From: Michael Eastham
Sent: 21 March 2018 12:26
To: Planning.Responses
Subject: FW: 4485 - Courtwick Littlehampton - variation of conditions 4 & 24 - Ref LU/408/17/PL

Would you like "Drawing Number 4485/314 Rev. E – North Eastern Footpath Link Details Plan" to be listed as an additional plan in the varied Condition 4, which was imposed on the outline planning permission (LU/355/10/)?

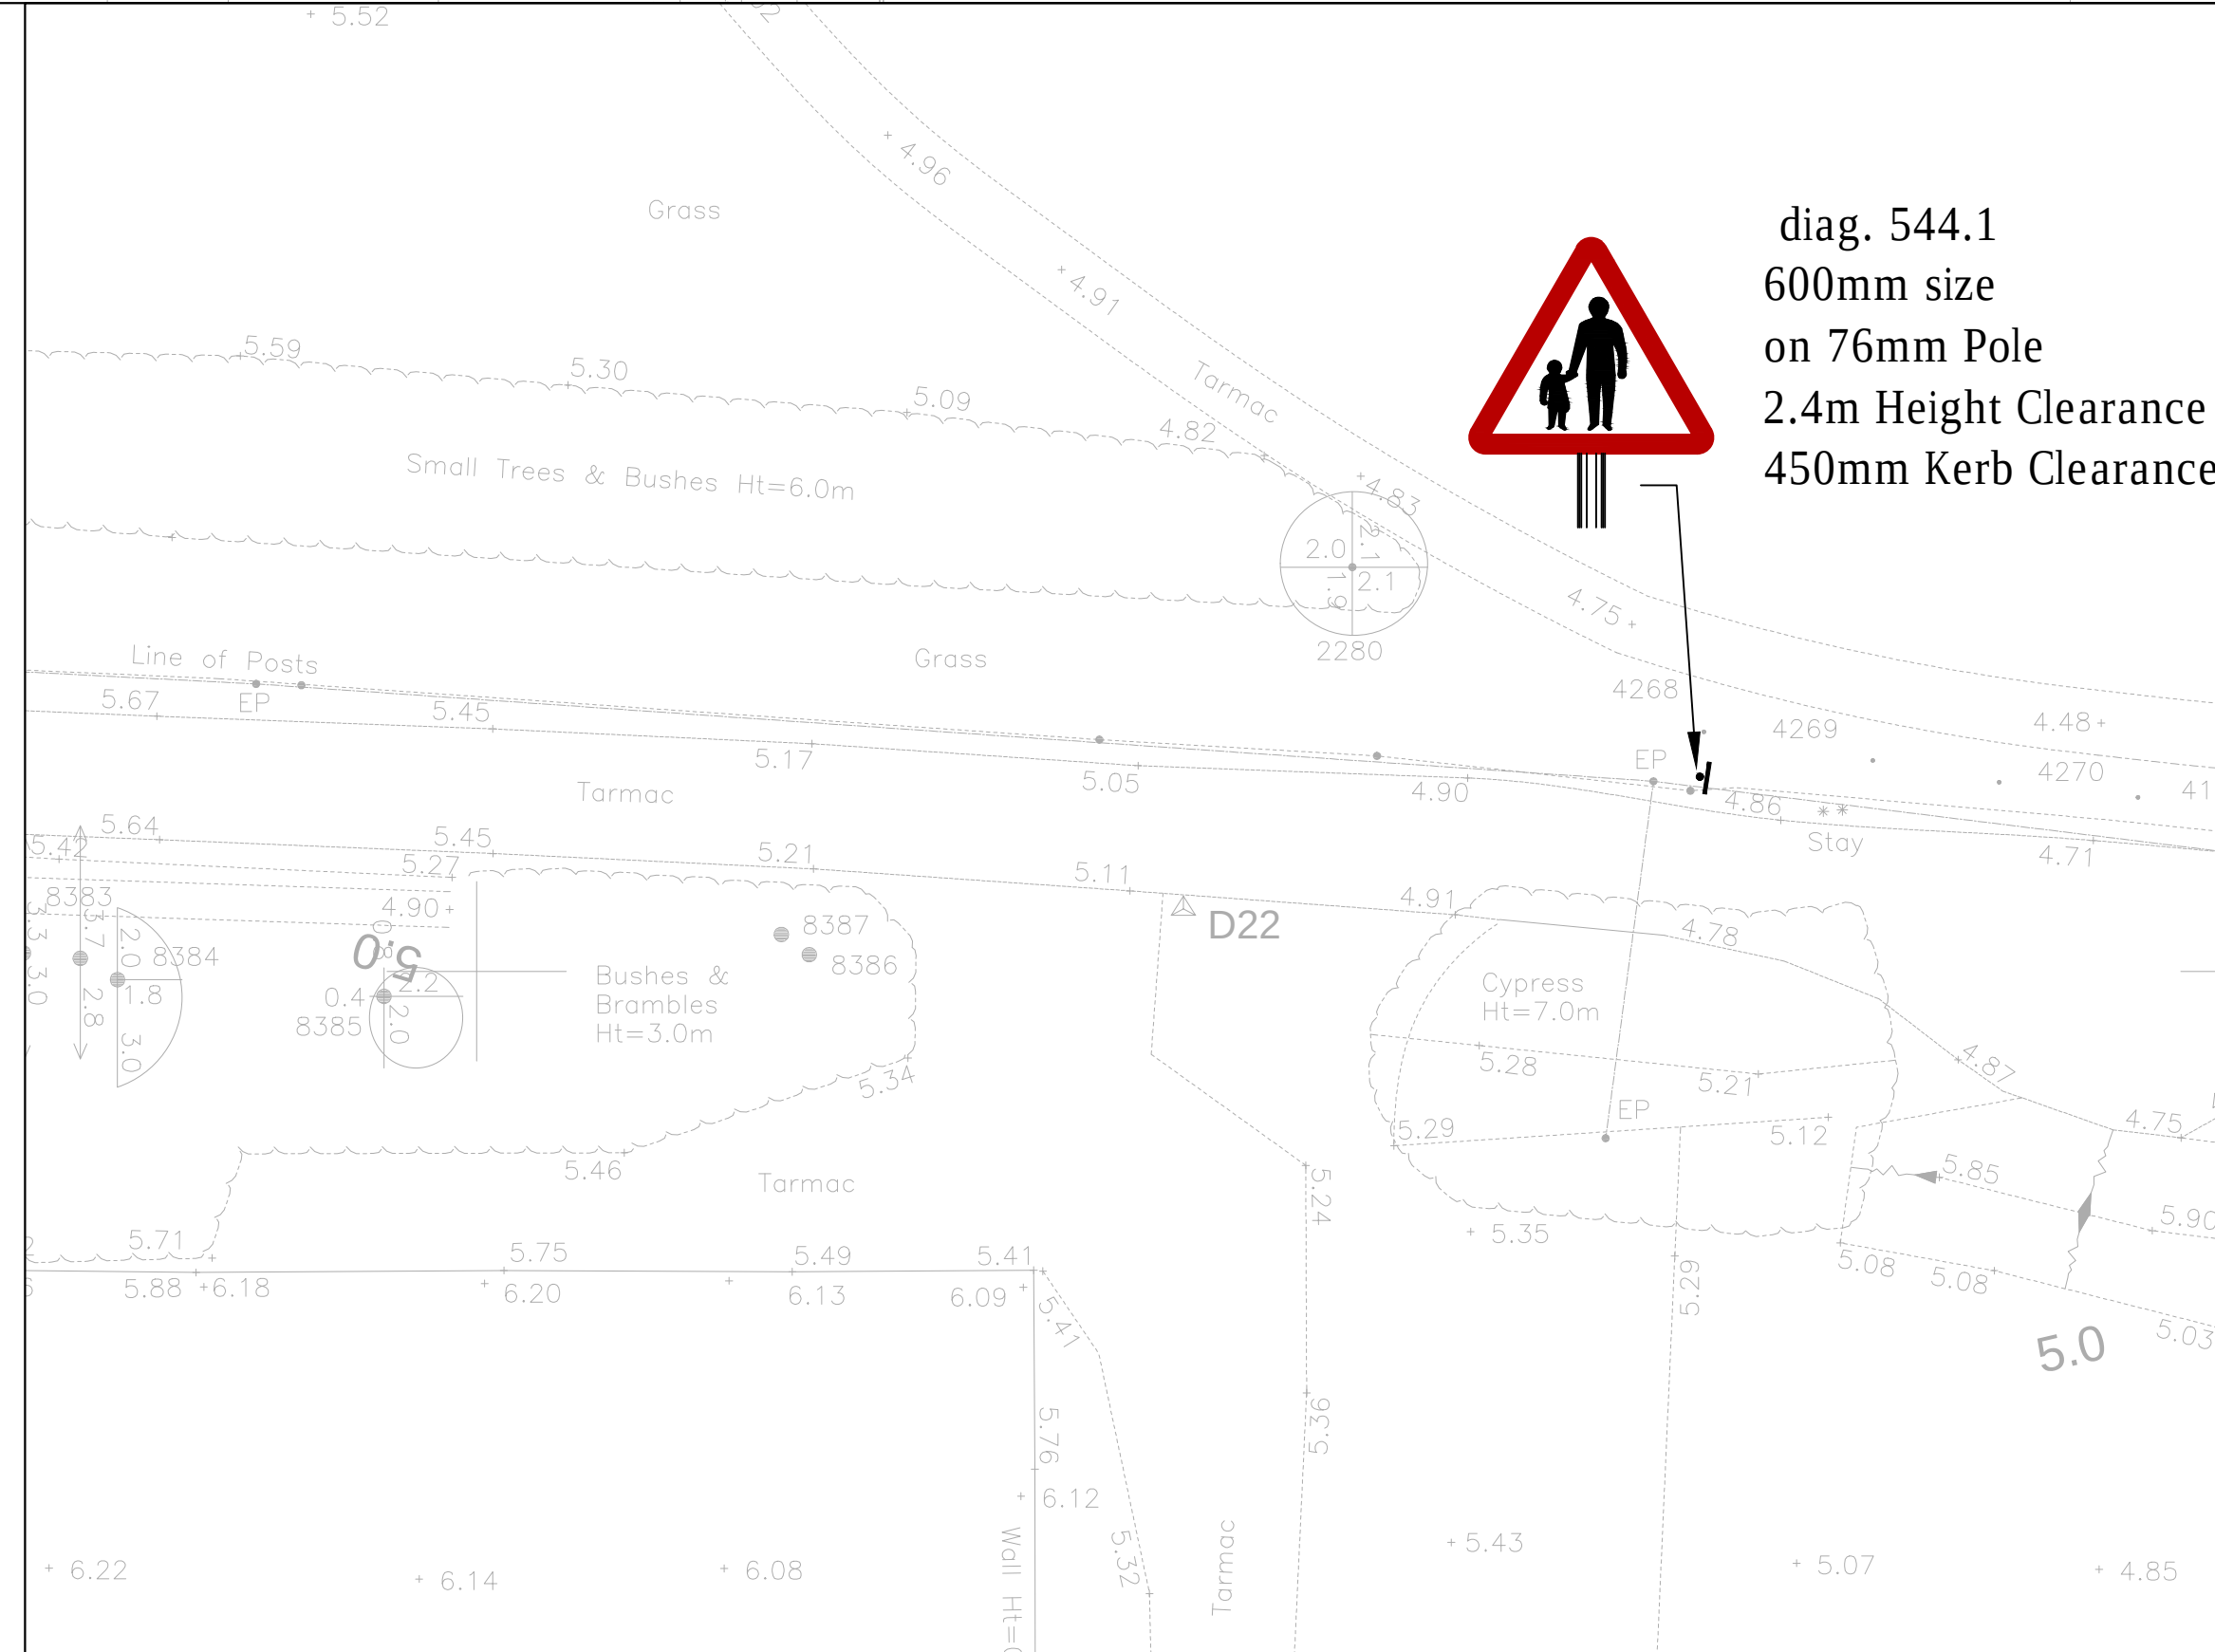
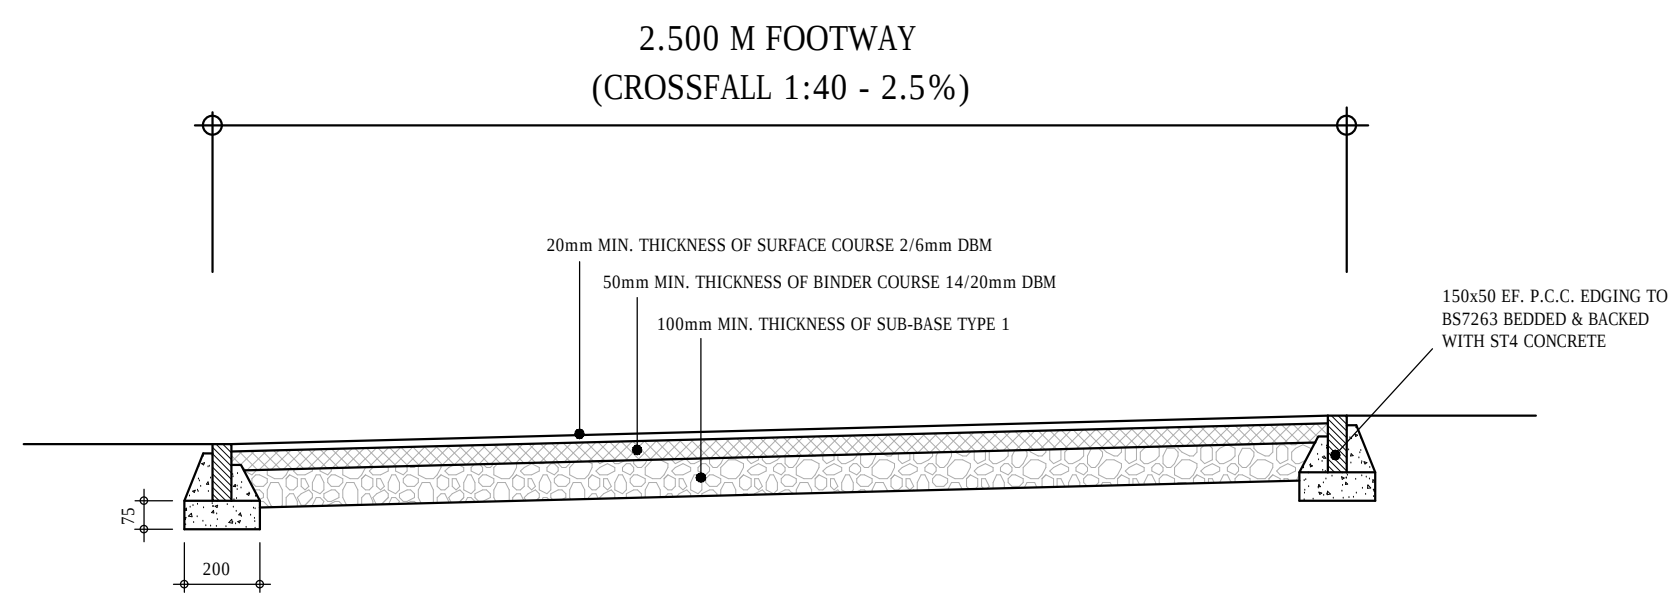
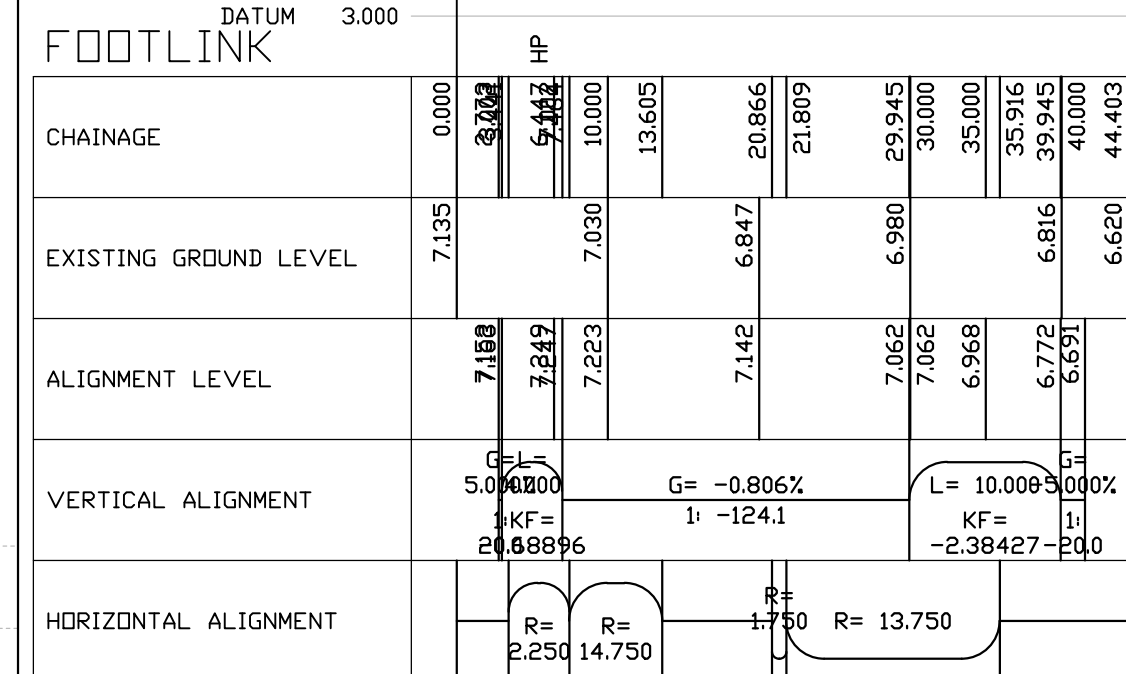
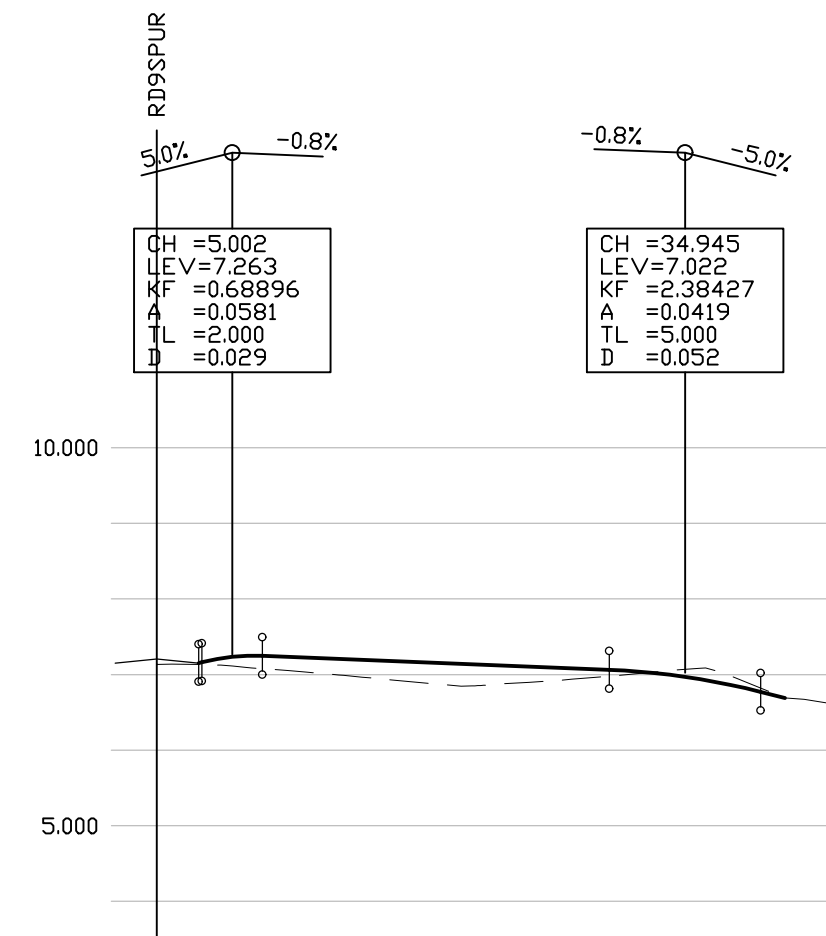
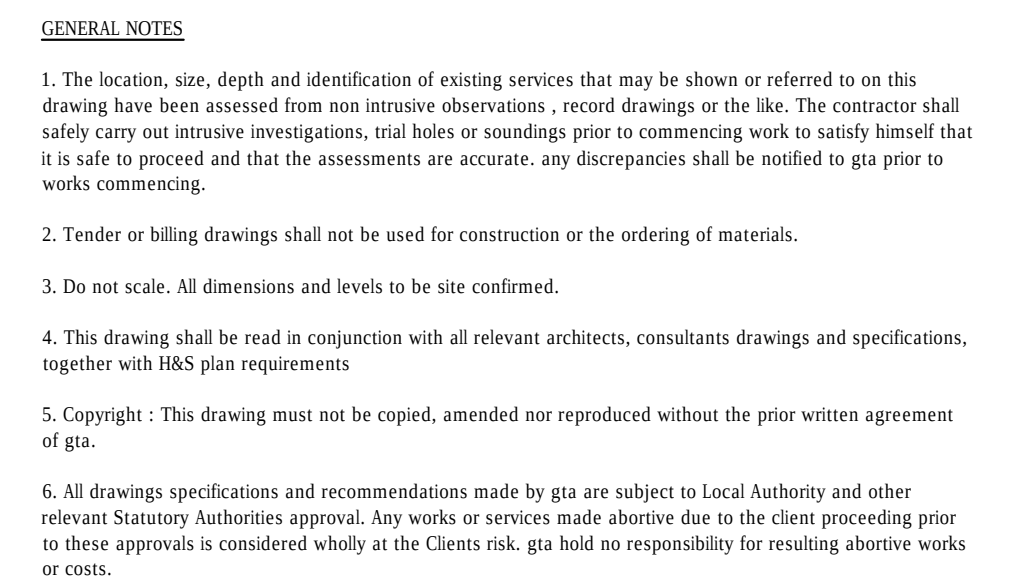
As far as I can see, the arrangements proposed by Bellway is still one that looks to be suited for cyclists. Furthermore, the stagger of the barriers might be the wrong-way-around and the use of hoops with 1200mm clearance underneath would permit a young child to walk or run underneath. They also might need to be a bit closer to the road (albeit not within the sight line splays). Finally, the gap in the middle would permit cyclists to traverse fairly quickly so should – I believe – be narrowed. However, the applicant would still have to demonstrate that those with pushchairs and mobility scooters can get through them. Sustrans guidance might assist here (*SEE LINK BELOW). Finally, there must be barriers (e.g. fence) either side to prevent the gates from being by-passed. In any event, appropriate design guidance will have to inform the final solution. However, it is still unclear what design guidance they have used to inform the proposal as the extract that you/they have provided is not one I have seen before. This should still be clarified, please.

Thank you Michael. This now appears acceptable.

Yes please list the drawing, however it is now revision F.

See attached drawings updated to reflect Tim's last comments.
